# Accessibility Report – DA Submission

**Project Title:** Toll IPEC Freight Transport Facility

**Date:** 27 November 2012

# DESIGN REVIEW – DA Stage

**TITLE**  
 SITE PLAN

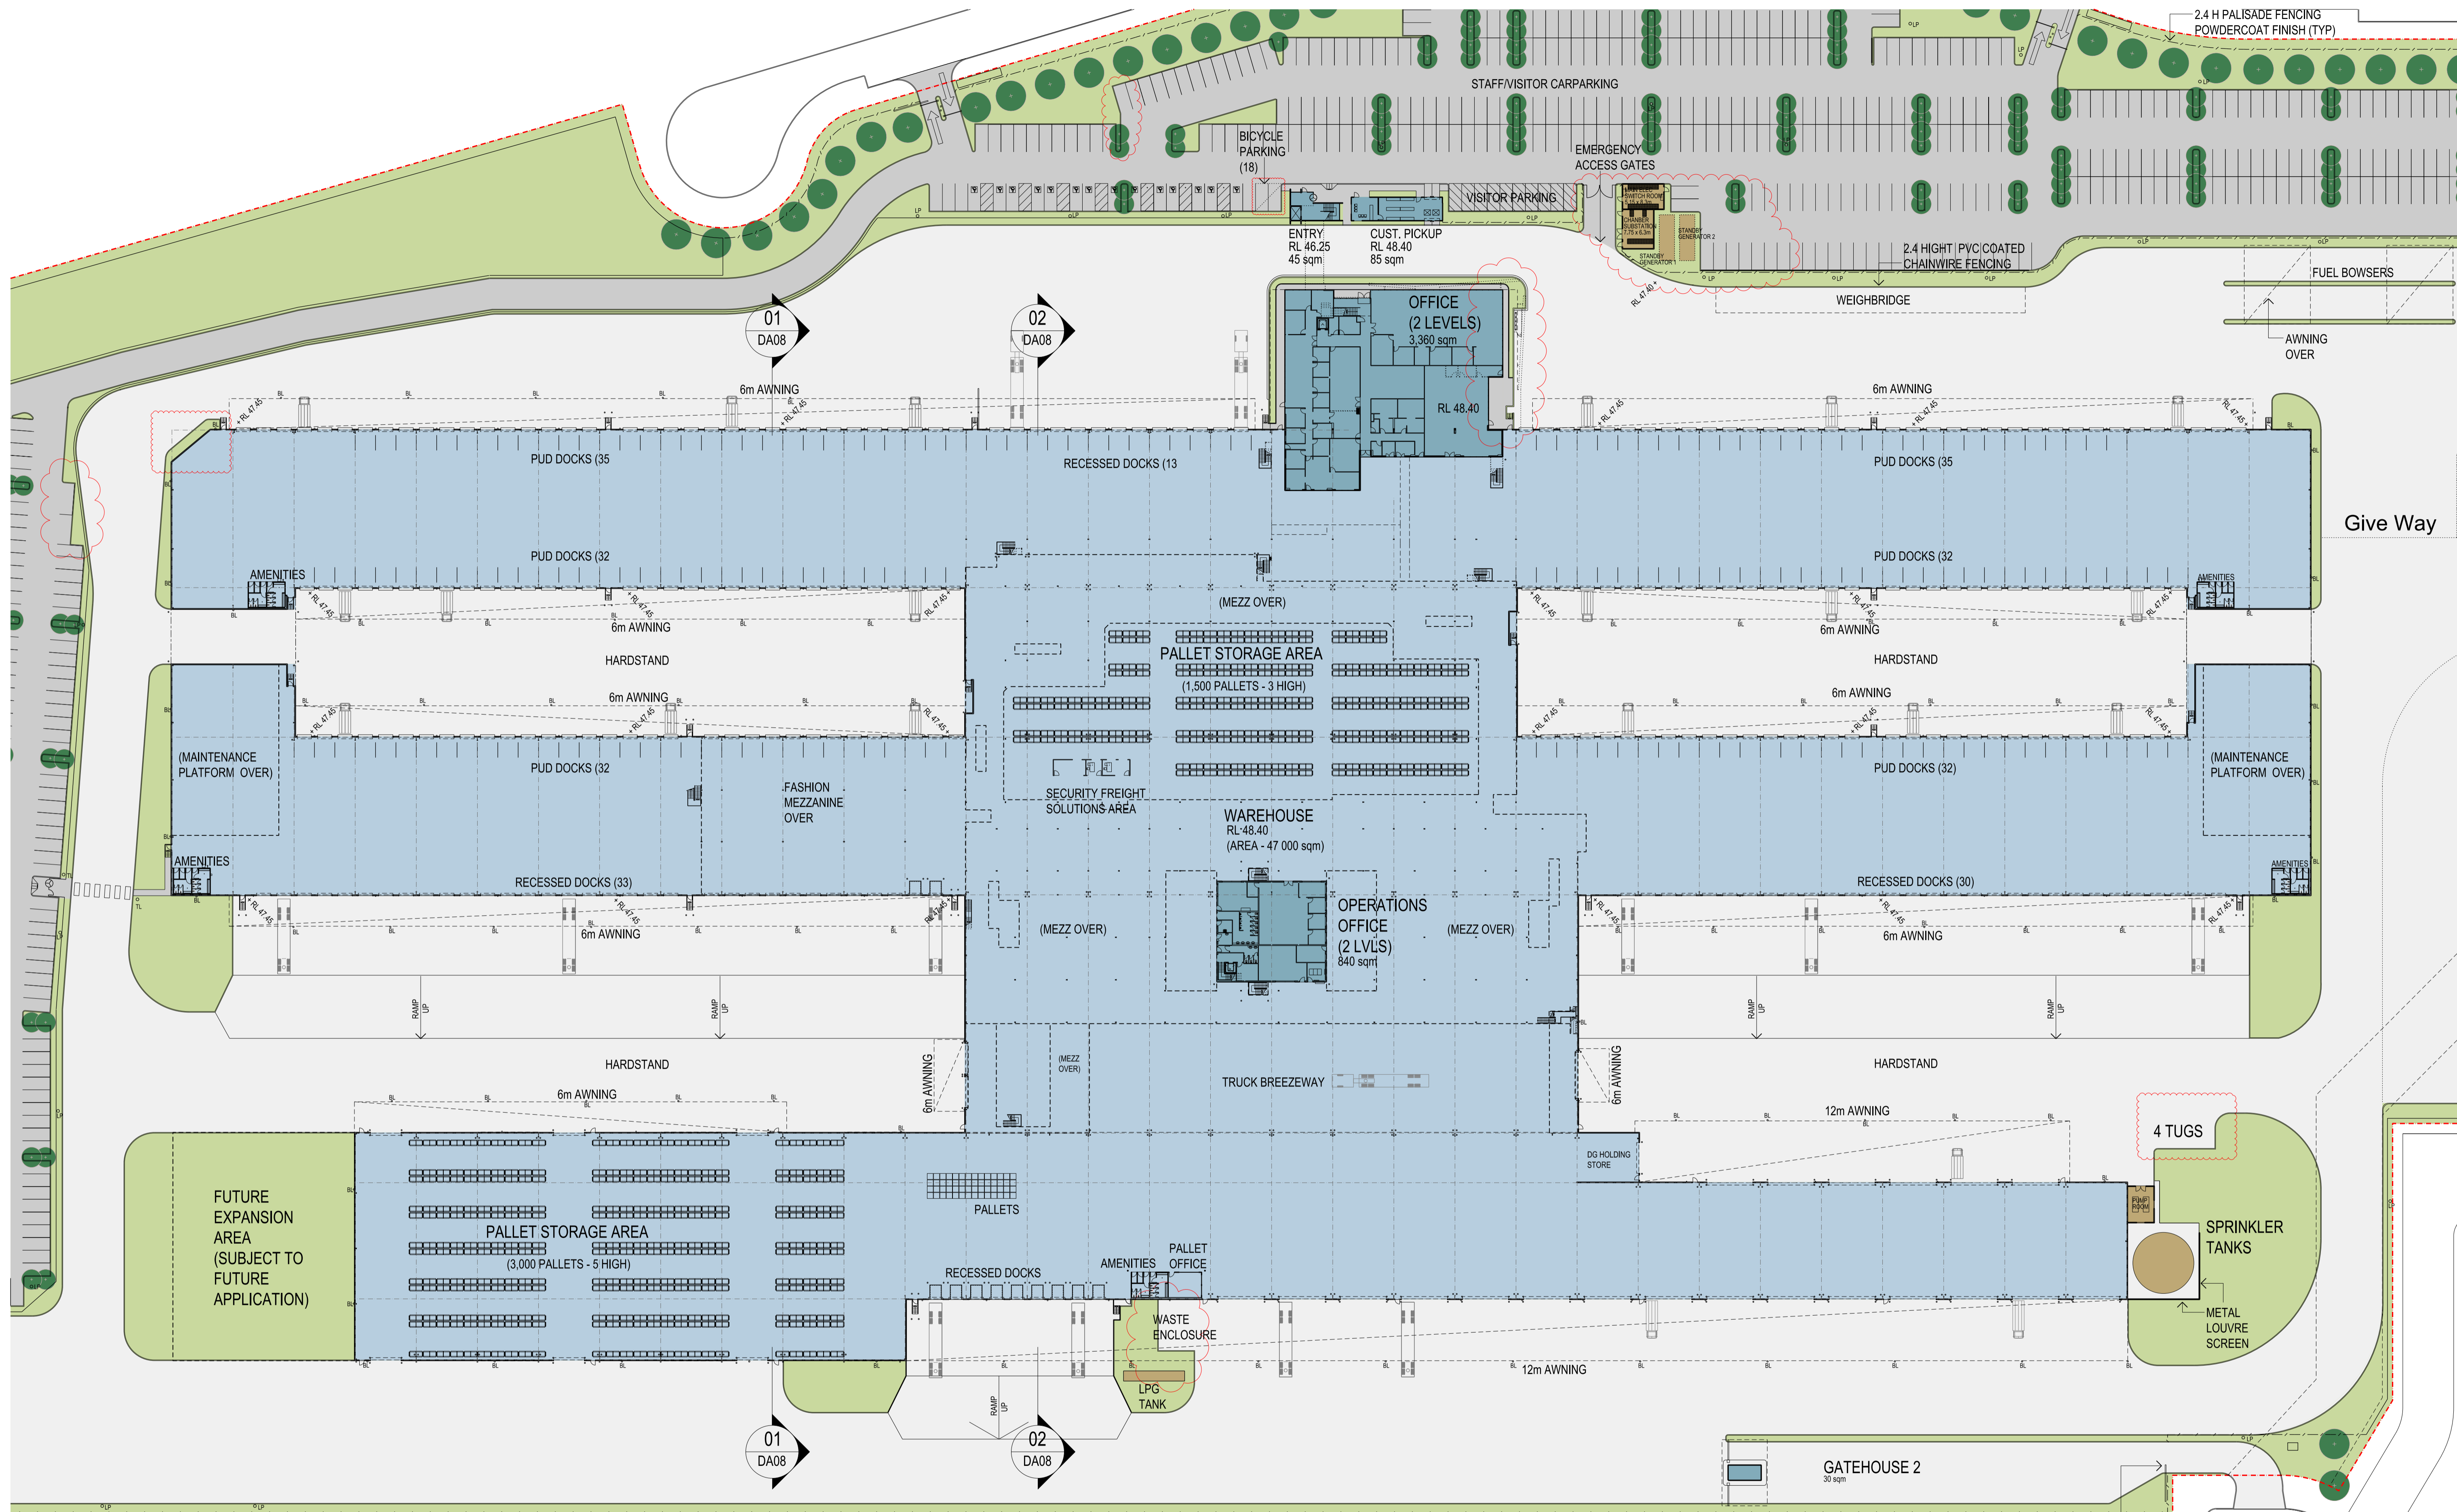
DWG No	Comment/Issue(s)	Recommendation(s)	Compliance Achieved
DA03	<ul style="list-style-type: none"> <li>Accessible carparking bays</li> <li>A total of 700 carparking bays are proposed</li> <li>A minimum of 1 accessible space for every 100 car parking spaces will be provided</li> </ul>	<ul style="list-style-type: none"> <li>14 accessible carparking bays are proposed.</li> <li>Accessible parking requires complying with BCA D3.5 and AS 2890.6-2009. Minimum dimension 2.4m + 2.4m shared zone width.</li> </ul>	YES
DA03	<ul style="list-style-type: none"> <li>Surfaces</li> </ul>	<ul style="list-style-type: none"> <li>Accessible car parking bay surfaces to comprise a firm plane surface with fall not exceeding 1:40 in any direction. A fall of 1:33 is acceptable if surface is bituminous seal and parking space is outdoors.</li> </ul>	Noted
<b>Key Car parking and transport design recommendations:</b> <ul style="list-style-type: none"> <li>Provide 1:100 accessible parking bays within total car parking.</li> <li>Dimensions of angled accessible parking bays 2400 x 5400mm with adjacent 2400mm x 5400mm shared area and bollard in shared area.</li> <li>Dimensions of parallel parking bays 3200mm x 7800mm. advise location at end of row.</li> <li>Provide direct kerb ramp access from adjacent to the accessible parking space to pathway.</li> <li>Accessible bays to be located near entrances.</li> <li>Provide a designated area for accessible drop off from private vehicles, taxis and community vehicles with kerb ramp access to the pathway.</li> </ul>

WAREHOUSE GROUND FLOOR PLAN

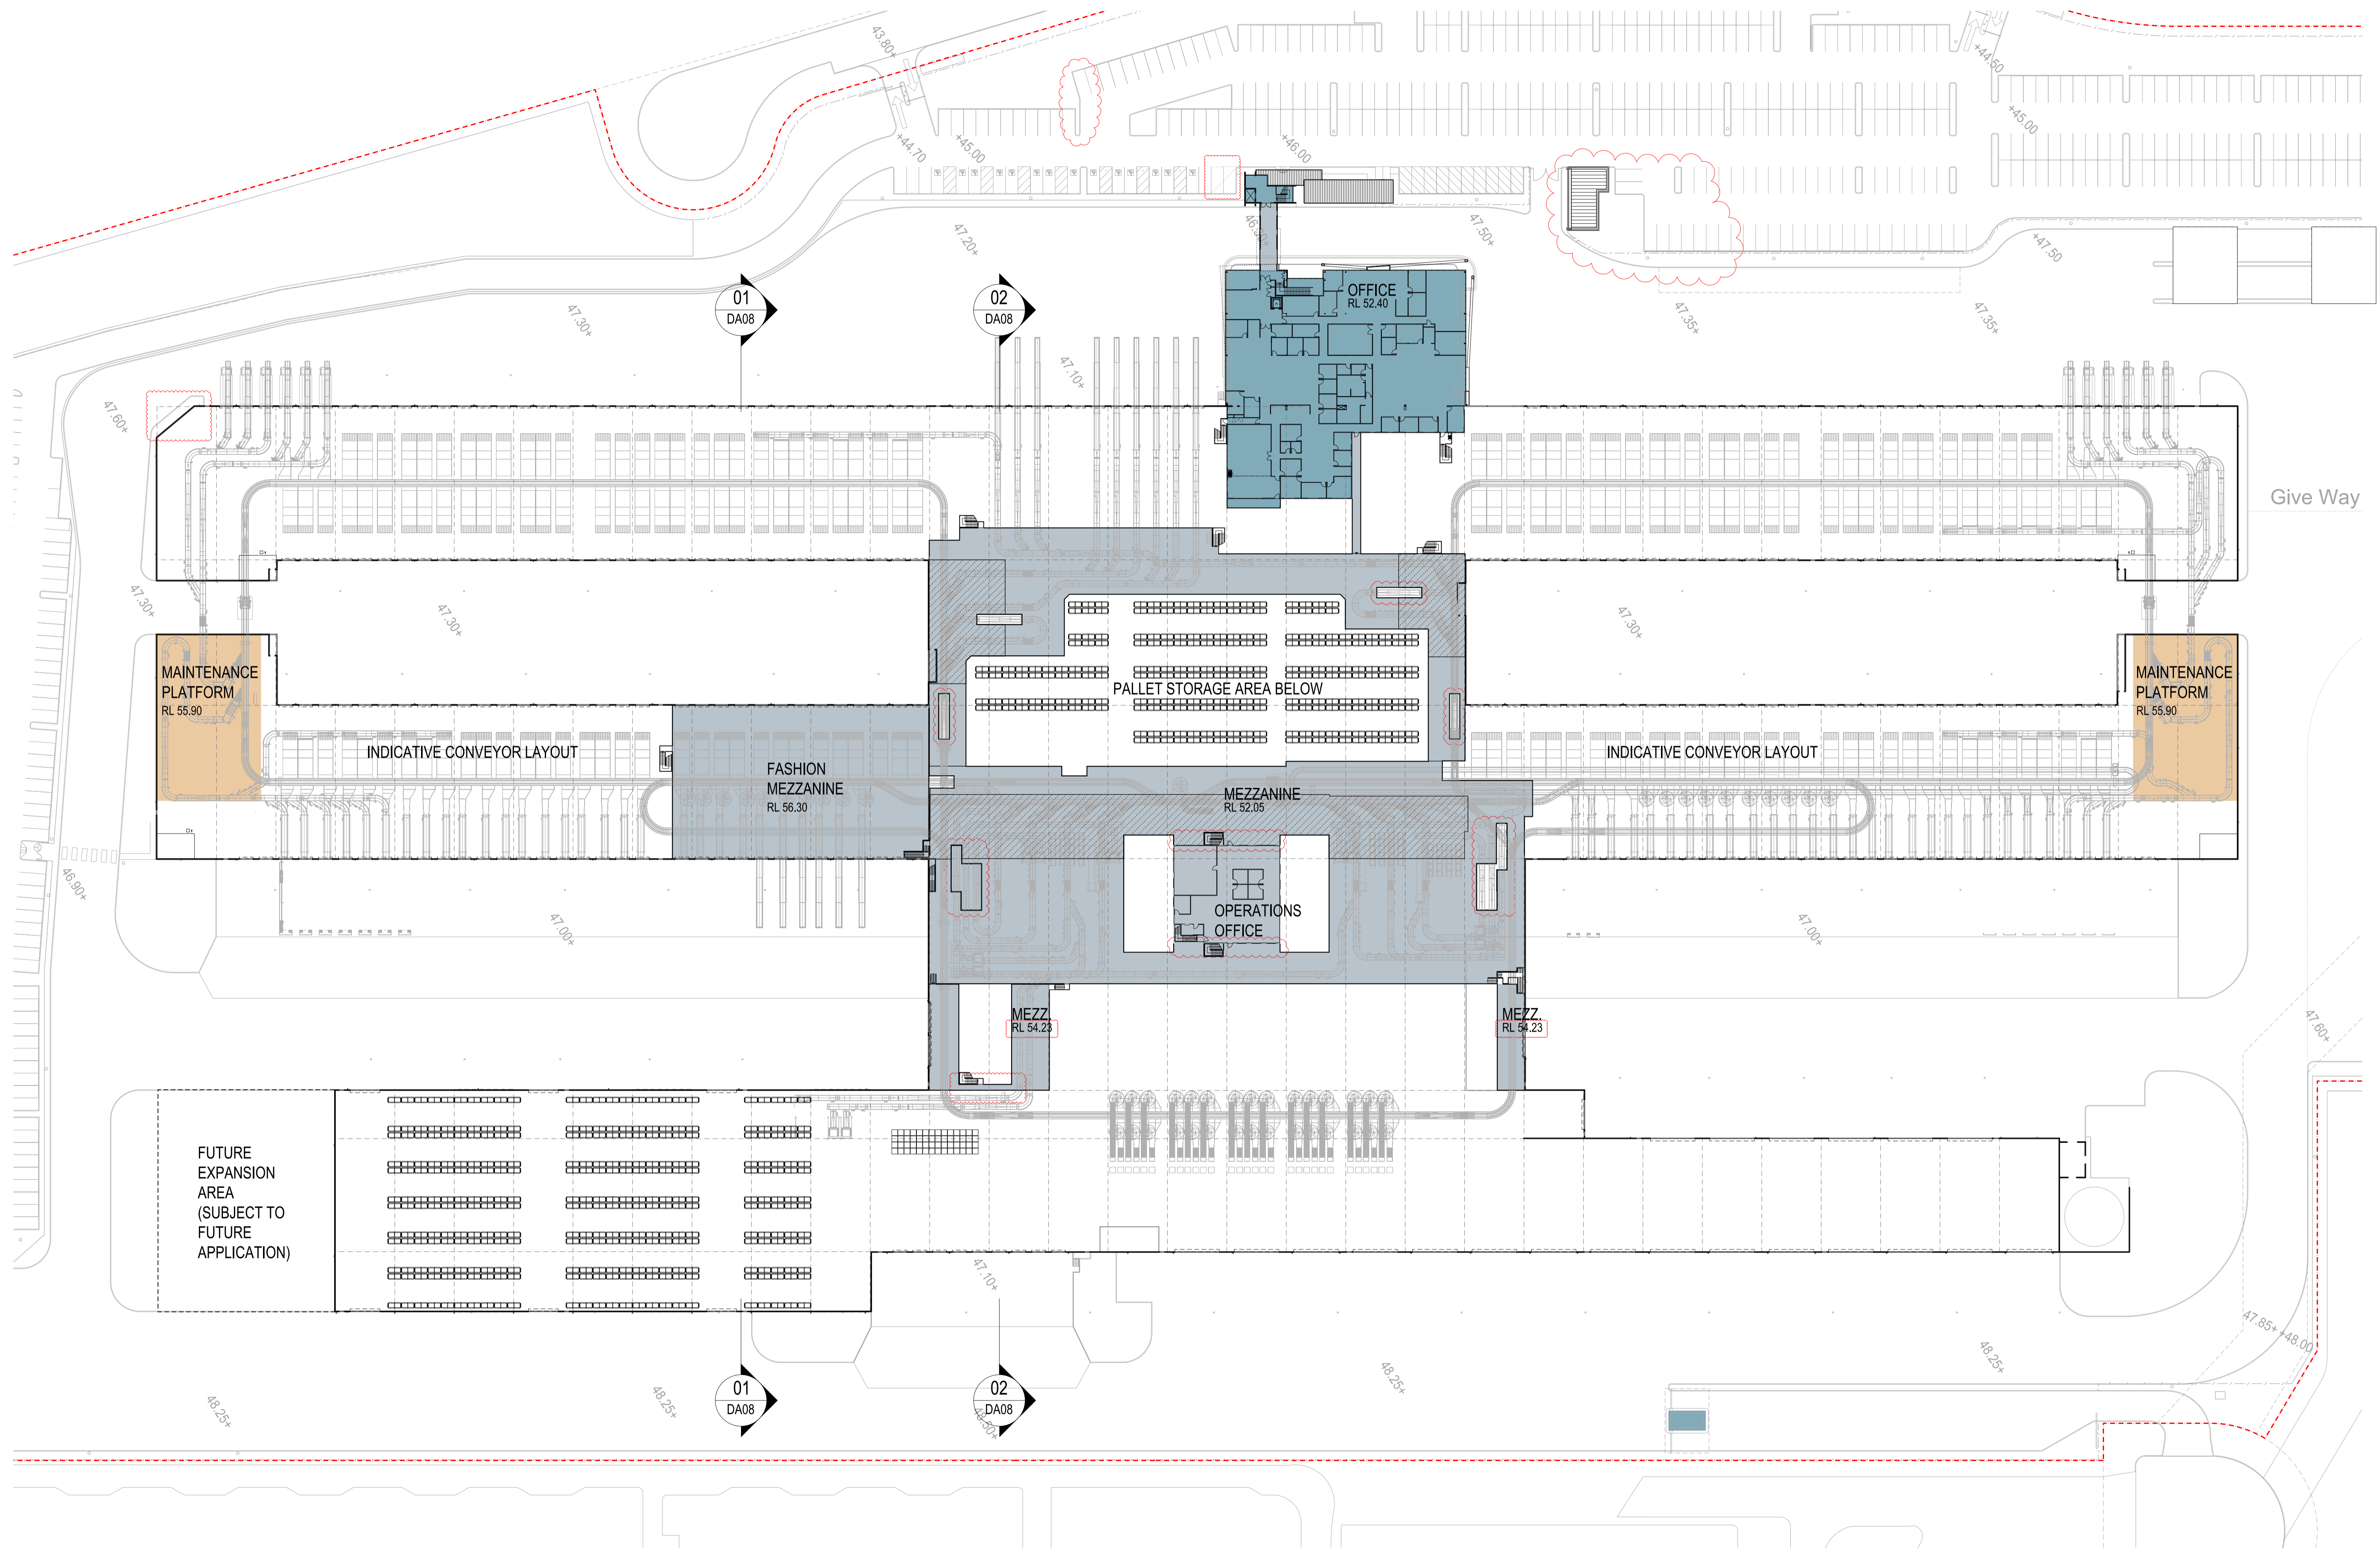
DWG No	Comment/Issue(s)	Recommendation(s)	Compliance Achieved
DA04	<ul style="list-style-type: none"> <li>• The principal pedestrian entrance is provided via the carpark area with level access</li> </ul>	<ul style="list-style-type: none"> <li>• Further review will be carried out at detail design stage</li> </ul>	YES
DA04	<ul style="list-style-type: none"> <li>• The entrance from south carparking area is not provided with level access</li> </ul>	<ul style="list-style-type: none"> <li>• That the entry be provided by way of ramp or level grade. To be reviewed prior to construction phase</li> </ul>	YES, Further review at CC stage
<i>Key entrance recommendations</i> <ul style="list-style-type: none"> <li>• Main entry must be accessible</li> <li>• other pedestrian entrances which is are not accessible must be located within 50m from an accessible pedestrian entrance.</li> <li>• Entry requires single door leaf width clearance of 850mm (920mm door size).</li> <li>• Circulation space of 1450mm required either side of entry. Minimum grade &amp; crossfall 1:40.</li> <li>• Entrance doors to have operational weight of less than 20N of force or be automated.</li> <li>• All frameless glazed doors must be marked with contrasting marking not less than 75mm wide for full width of doors with lowest edge at 900-1000mm.</li> </ul>
